RE: Volcano Cliffs Subdivision Lot 7 Block 8 Unit 18 6509 Canavio Pl NW Grading and Drainage Plan **Engineers Stamp Date 1/30/17 (D10D003O7)**

PREPARED BY STEVEN J. METRO, PE AND PS GRADING & DRAINAGE PLAN 6509 Canavio Pl, NW LOT 7, BLOCK 8, UNIT 18 VCS

Based upon the information provided in your submittal received 1/17/17, the above referenced Grading and Drainage plan dated 1/17/17 cannot be approved for Grading Permit until the following comments are addressed:

**GRADING AND DRAINAGE PLAN**  
**LOT 7, BLOCK 8, UNIT 18, VCS**  
**ADDRESS: 6509 Canavio PL NW**

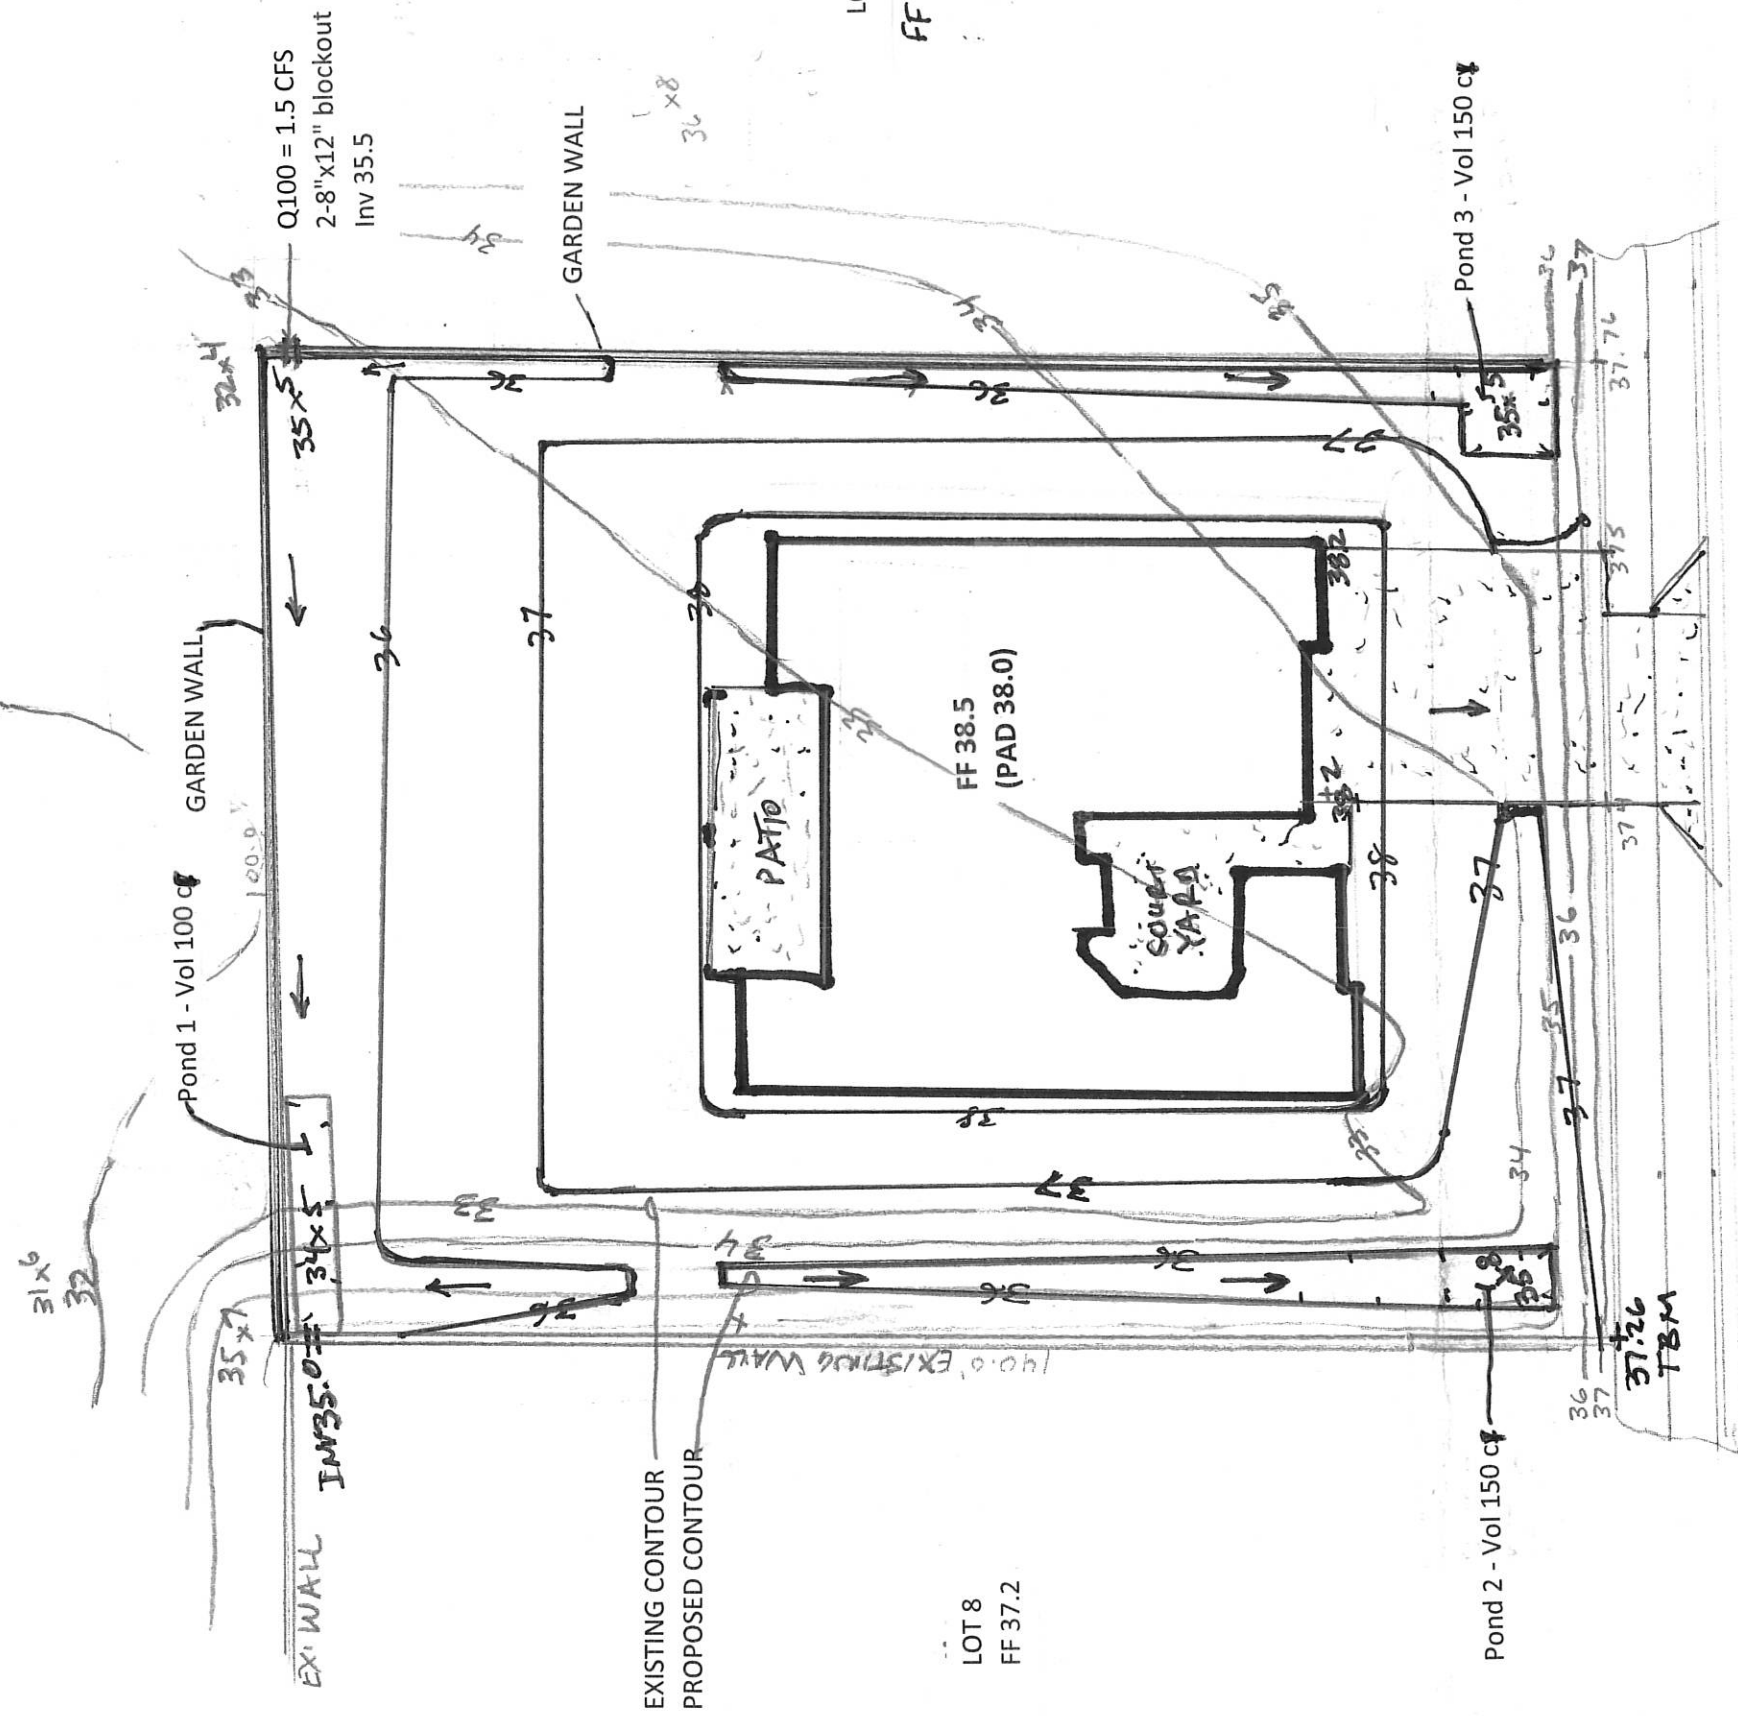
- Provide a note stating that future garden walls require a separate permit and this plan should be used for their placement.
- Provide a statement that a pad certification is required before a building permit is given.
